Planning Application No: 3/2026/0042

Proposal: Outline application for the proposed erection of two dwelling houses with access applied for.

Location: Land adjacent to Fernhill Ribchester Road Clayton Le Dale BB1 9EG

RE: Planning Application No 3/2026/0042 Grid Ref: 367150 433327

**Habitat Map**

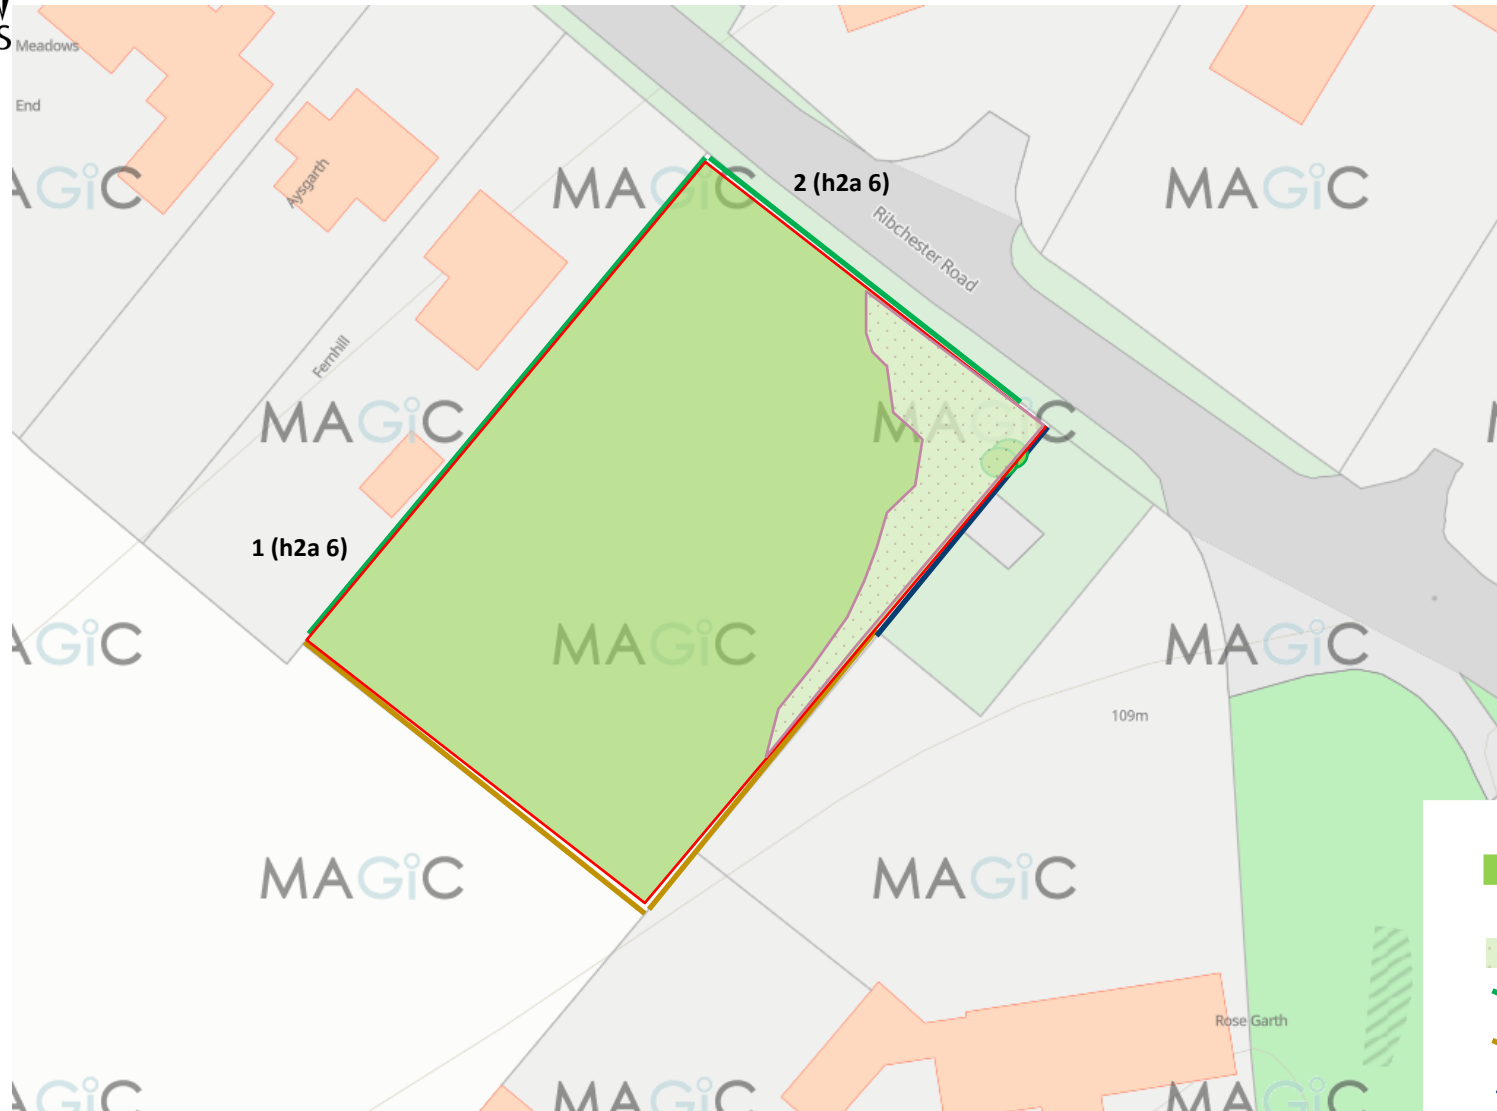
The biodiversity net gain report provided does not take into account loss of habitat.

PROPOSED SITE PLAN  
 (option 1)

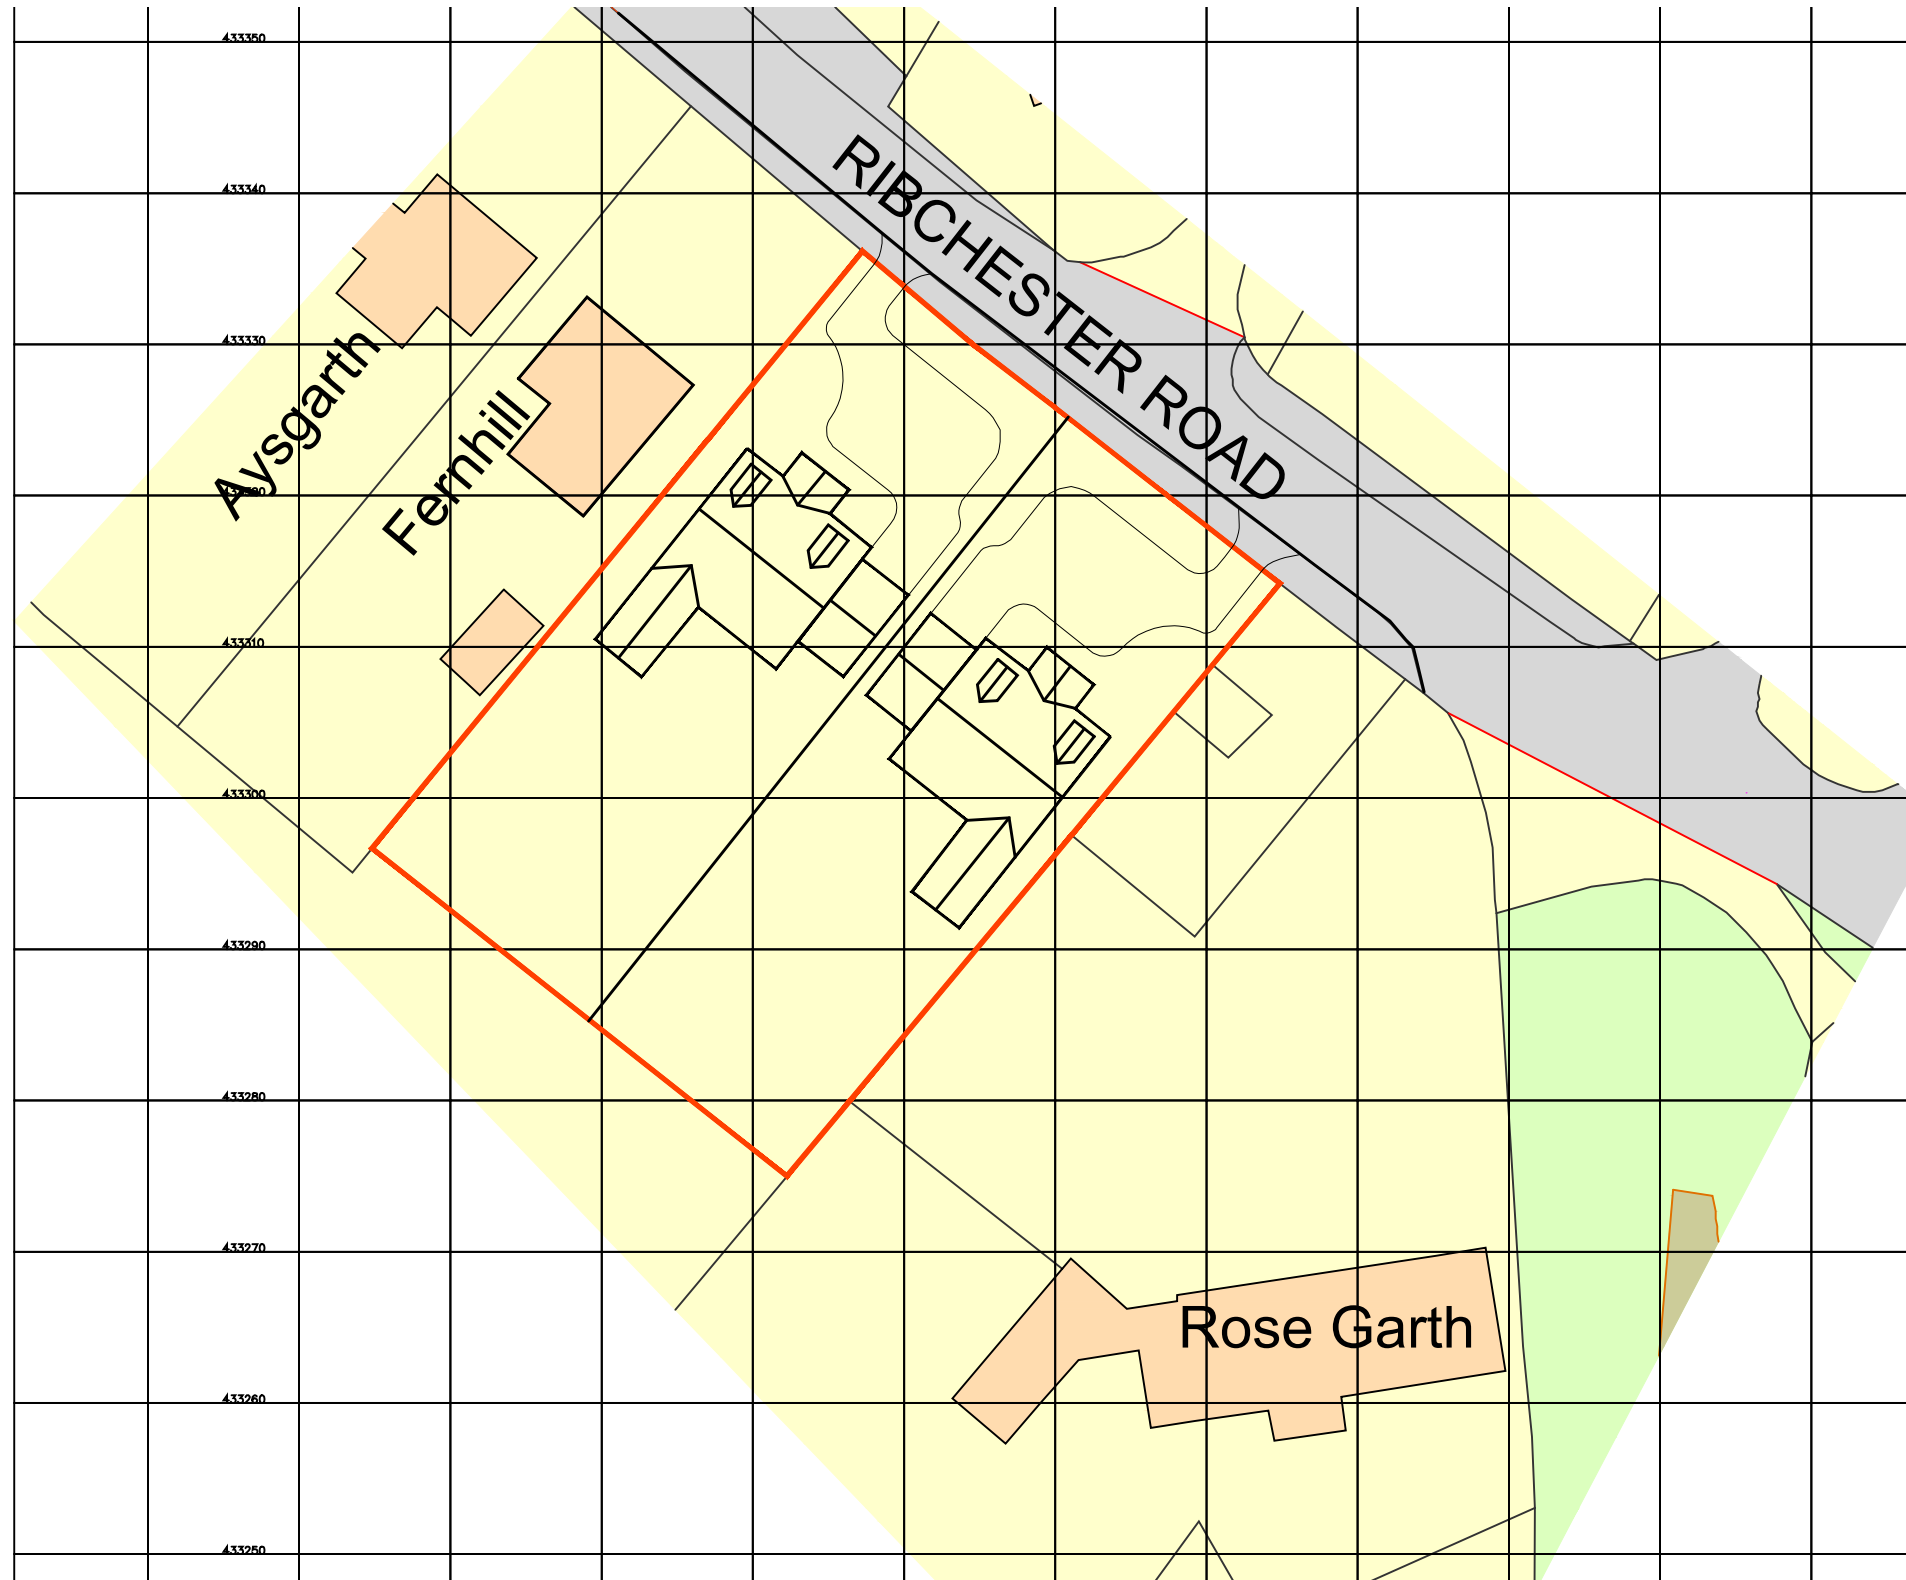
The entrance to Oaks Quarry Garage is less than 50m from the proposed development. Many large articulated lorries enter and exit Oaks Quarry Garage at all times of the day. Visibility for lorries exiting Oaks Quarry Garage is poor and visibility of cars leaving the proposed development is limited by a large stone wall and a large hawthorn tree belonging to 197 Ribchester Road.

This increases the chances of a road traffic accident for cars entering and exiting the proposed development.

The proposed development is on a site that is currently grassland which absorbs rainfall and reduces the impact on localised flooding during periods of heavy rain. Due to the sloped nature of the site towards Ribchester Road, any building or landscaping, even if they are of a permeable nature, will contribute to additional water entering Ribchester Road, exacerbating the localised flooding at Oaks Bar.

[REDACTED] the proposed development. The house was [REDACTED] [REDACTED] the proposed site. One of the houses in the proposed development would be [REDACTED]. This would allow the occupants to have direct visibility [REDACTED], particularly at night. This would result in a significant loss of privacy for the occupants. We would not have specified [REDACTED] [REDACTED].
